KIRKLEES METROPOLITAN COUNCIL INVESTMENT & REGENERATION SERVICE

DELEGATED DECISION TO DETERMINE PLANNING APPLICATIONS

Reference No:	2022/62/90952/W
Site Address:	52, Gledholt Road, Gledholt, Huddersfield, HD1 4HR
Description:	Alterations to dwelling to form House in Multiple Occupancy (HMO) comprising 8 bedrooms, demolition of outbuilding and boundary wall, formation of parking spaces and erection of replacement boundary wall and fence (within a Conservation Area).
Recommending Officer:	William Simcock

Officer Report 2022/90952 52 Gledholt Road HD1 4HR

Section AA
1 : 100

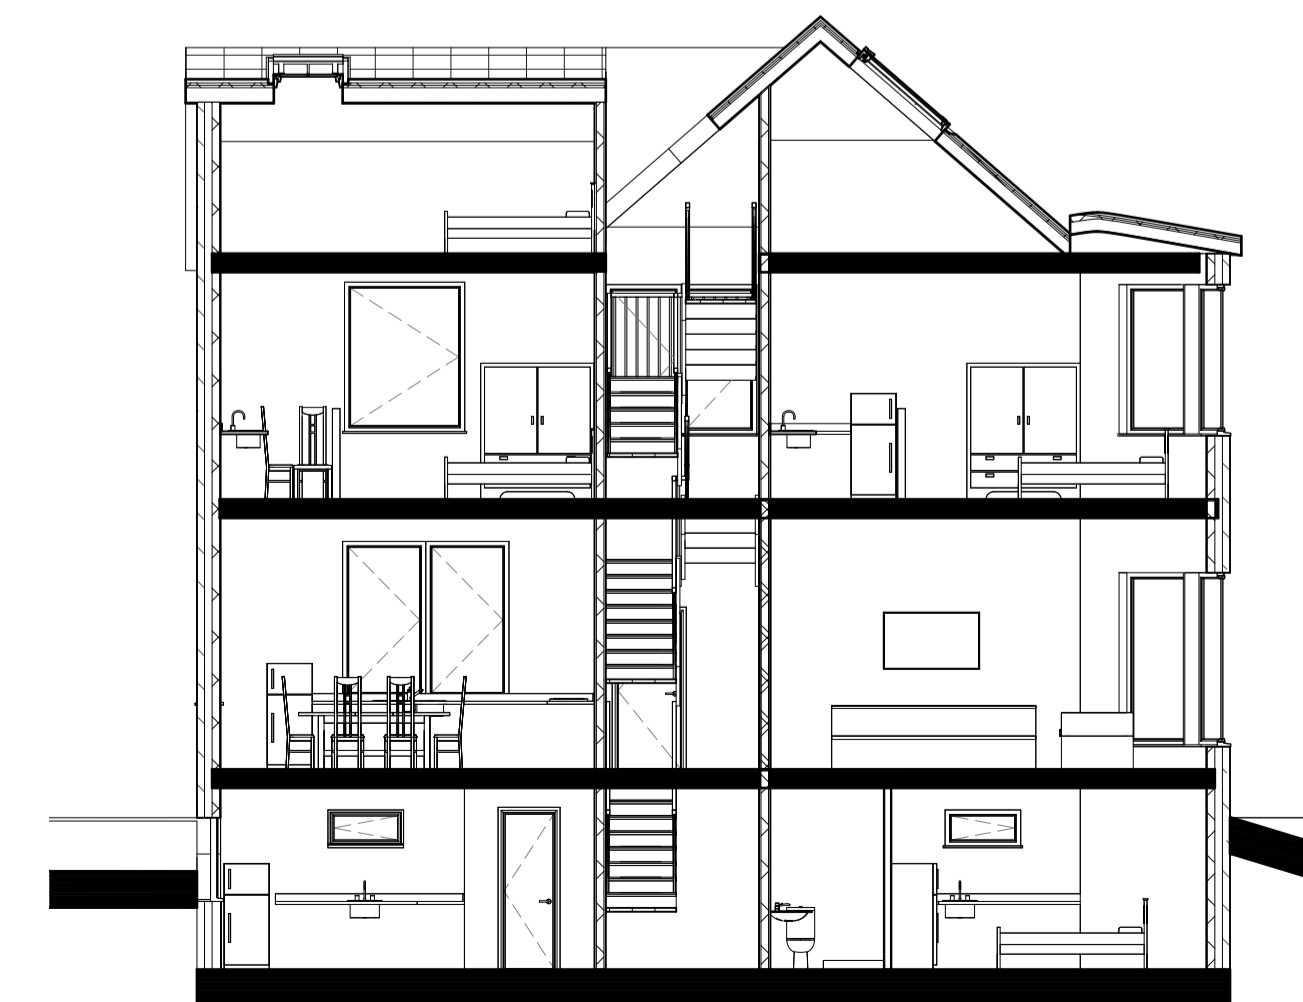
The rear windows would look out towards no. 89a Grasmere Road. The relationship between the two properties would be changed in so far as the building would be more intensively used and because of the demolition of the old outbuilding which at present forms the boundary wall between the two properties. The distance between facing windows would be approximately 30m, which is in excess of that required for new properties in the Housebuilders' Design Guide. The applicant has confirmed that their intention is to demolish the outbuilding / retaining wall and rebuild it to a lesser height, with the main boundary treatment being a new timber fence to be erected behind the wall. The sectional drawings show that it would be high

enough to prevent mutual overlooking between no. 52's land and no. 89a Grasmere Road.

It is recommended it be conditioned that the new fence is built before any part of the development is brought into use and thereafter retained, in the interests of privacy. Subject to this condition it is considered that the development would safeguard the amenities of existing residents and be in accordance with the aims of LP24(b) and paragraph 130(a&f) of the NPPF.

Lower Ground Floor  
1 : 50

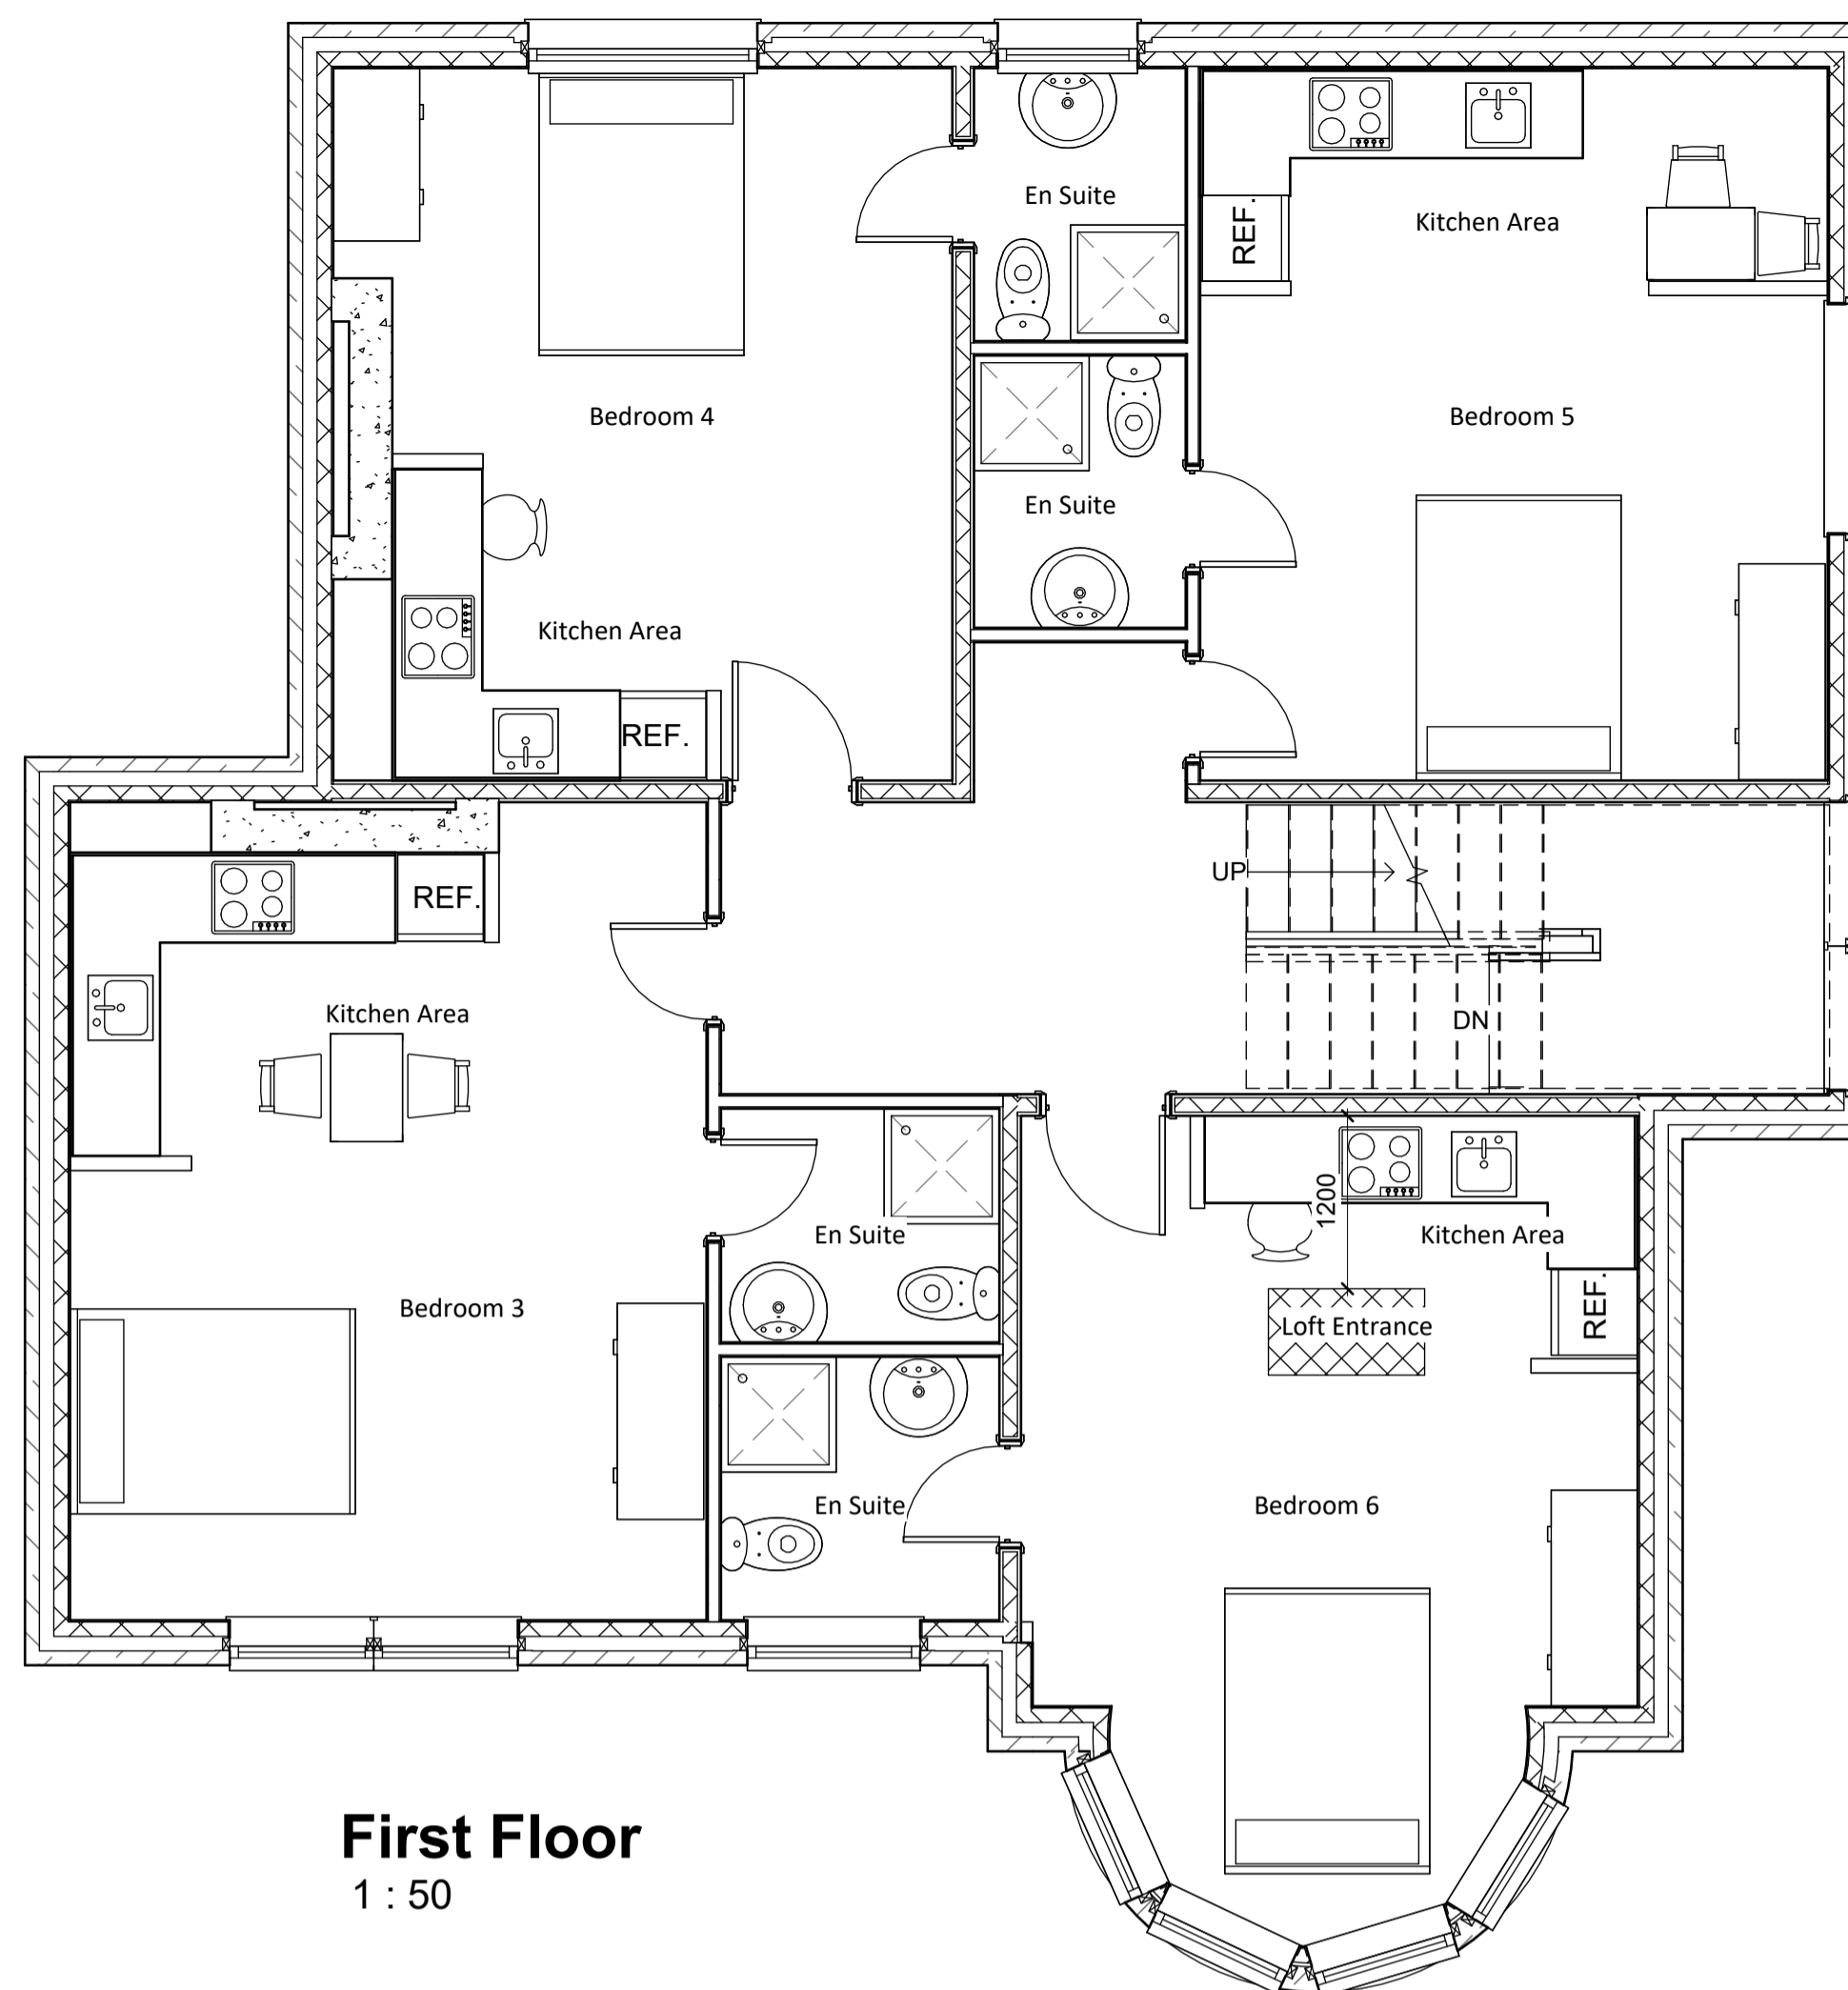
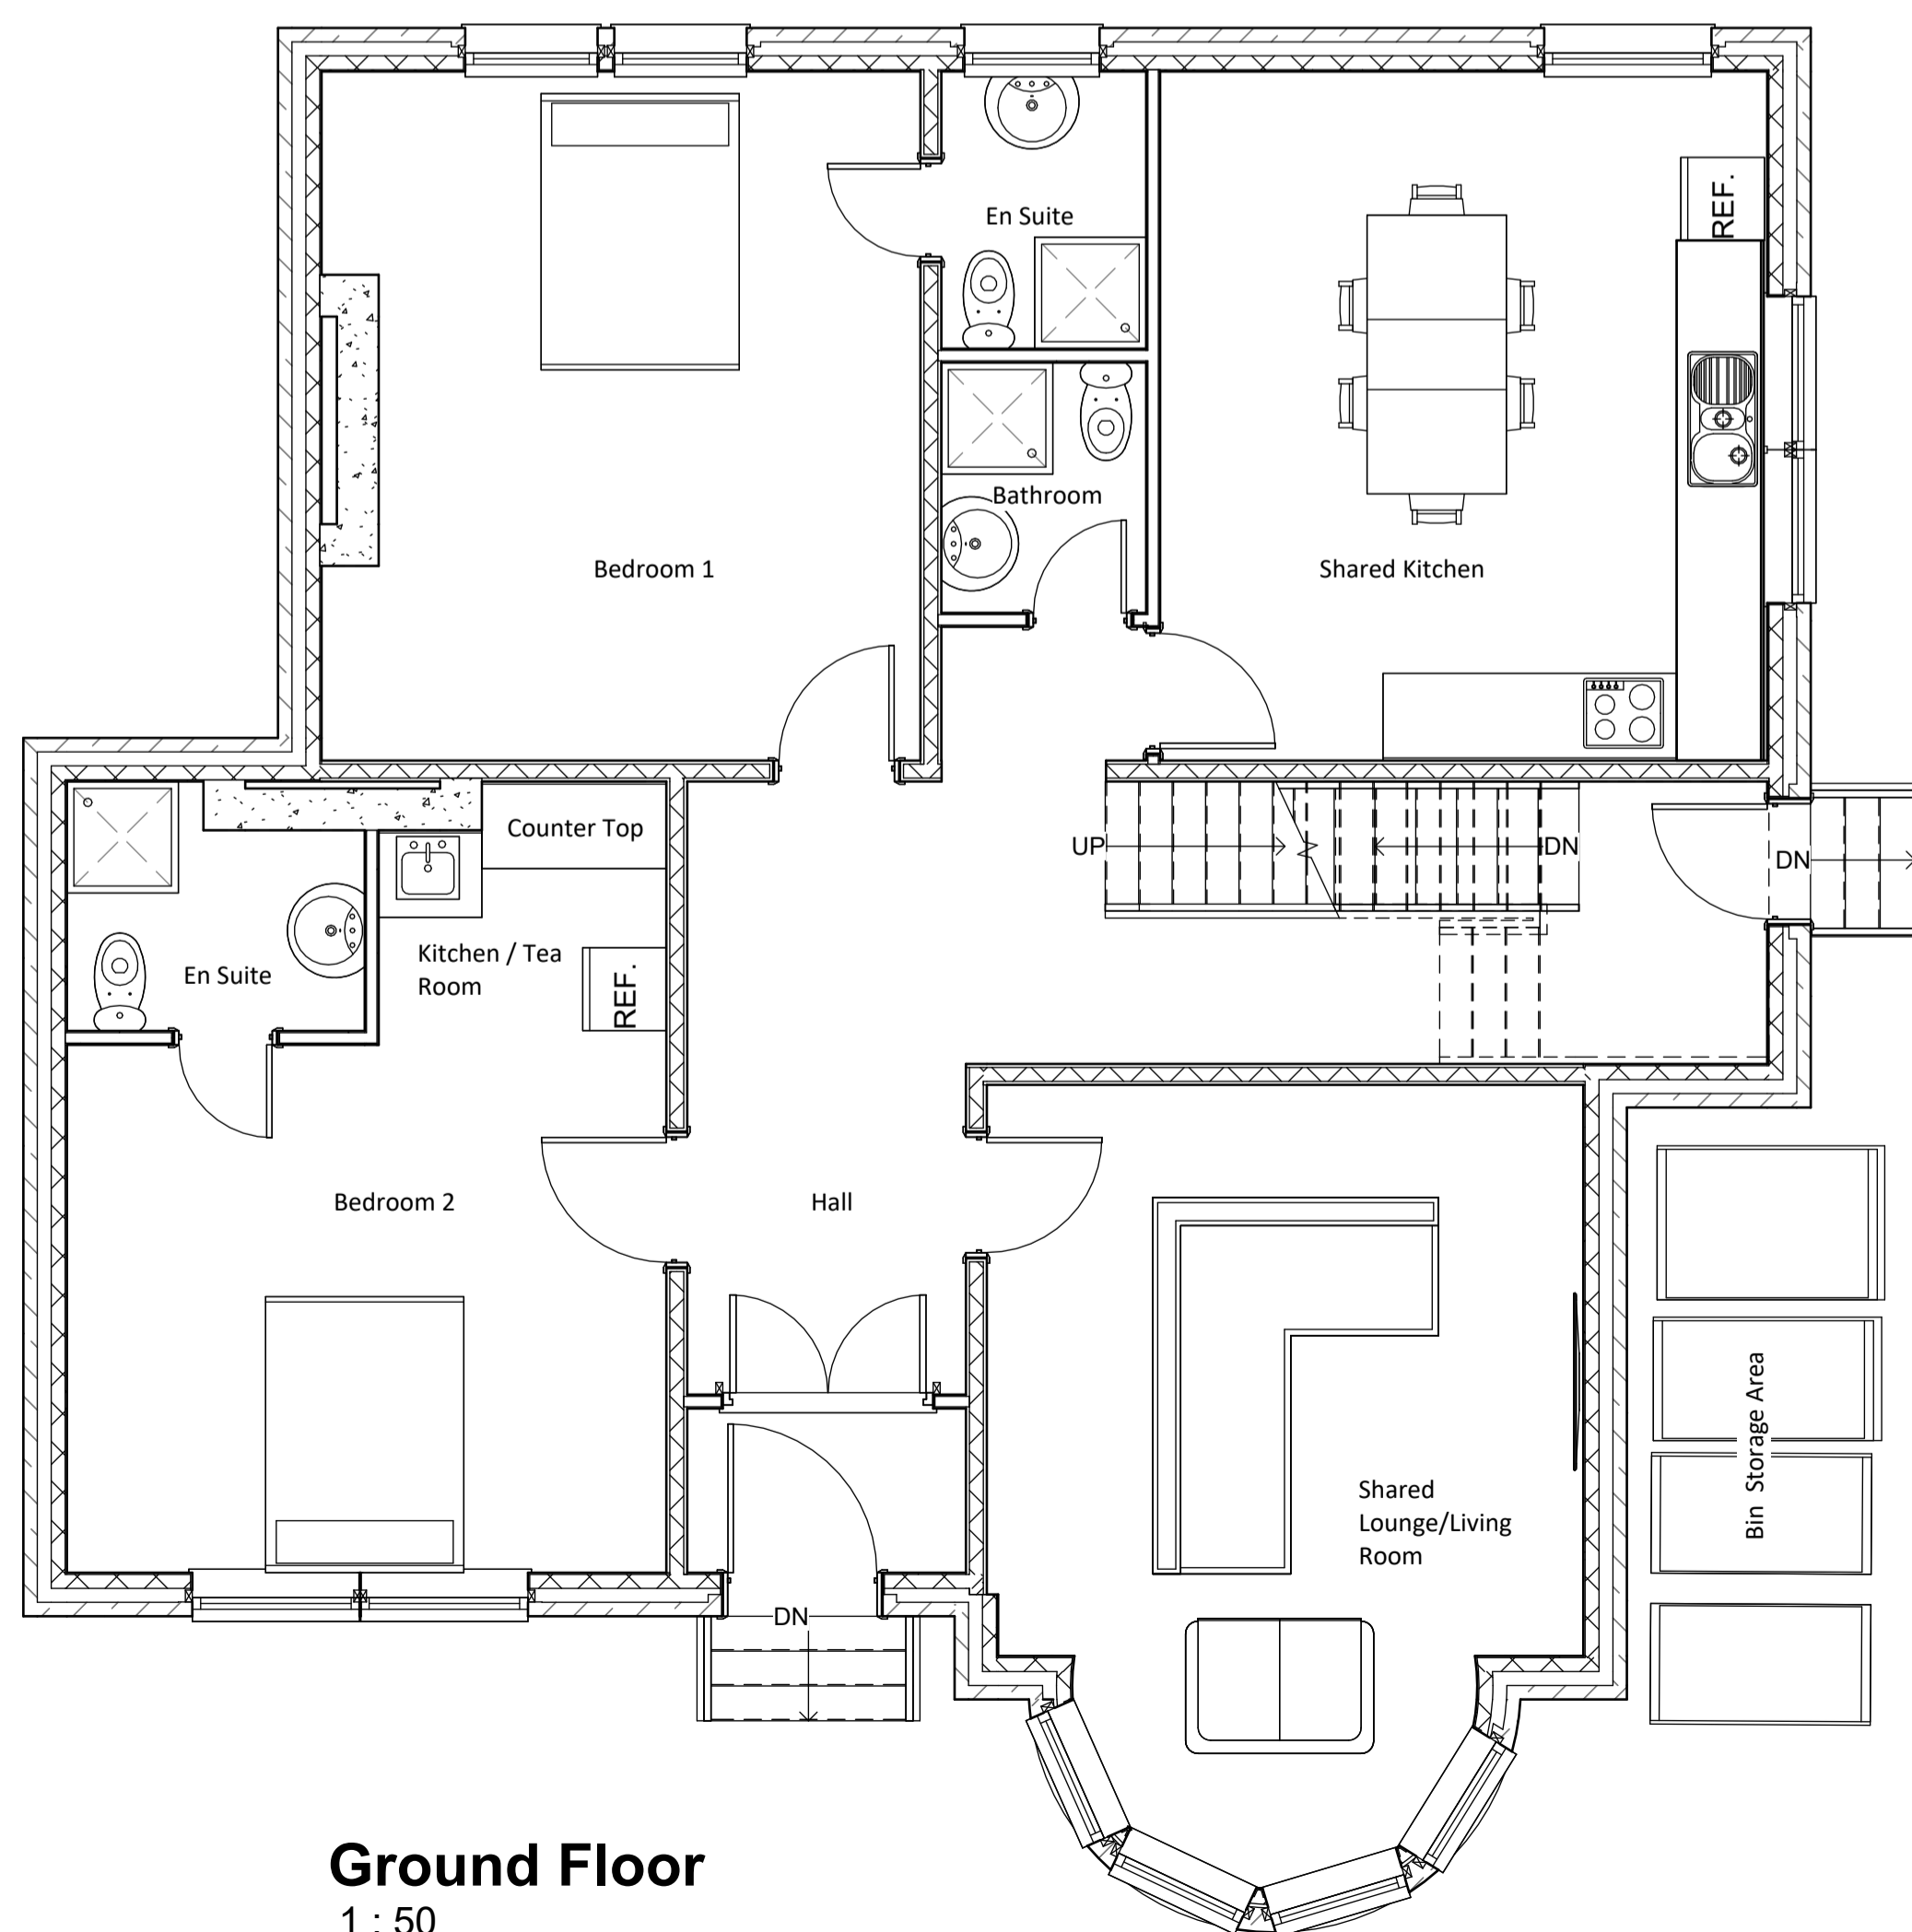
The earliest version of the plan which showed bedrooms in the basement would have been unacceptable because of limited light and outlook, and this has now been rectified – all bedrooms are at ground floor or above. Whilst outlook for the occupants of bedrooms 7&8 would be more limited than for the other rooms since they would be reliant on rooflights only, it is considered that they would receive adequate levels of natural light. The outlook for bedroom 4 would be over the car parking spaces (including one just beneath the window) but since the ground floor of the property is elevated compared the level of the proposed car park, it is considered that its outlook and ability to receive natural light would not be severely compromised. All bedrooms, including the second-floor or attic bedrooms, would be in excess of the minimum floorspace set out in the Nationally Described Space Standards. The occupants would be provided with what is considered to be an adequate amount of shared or communal space, comprising the basement rooms, main living room and kitchen at ground floor, the smaller shared kitchen / living room at the uppermost floor, and attic storage.
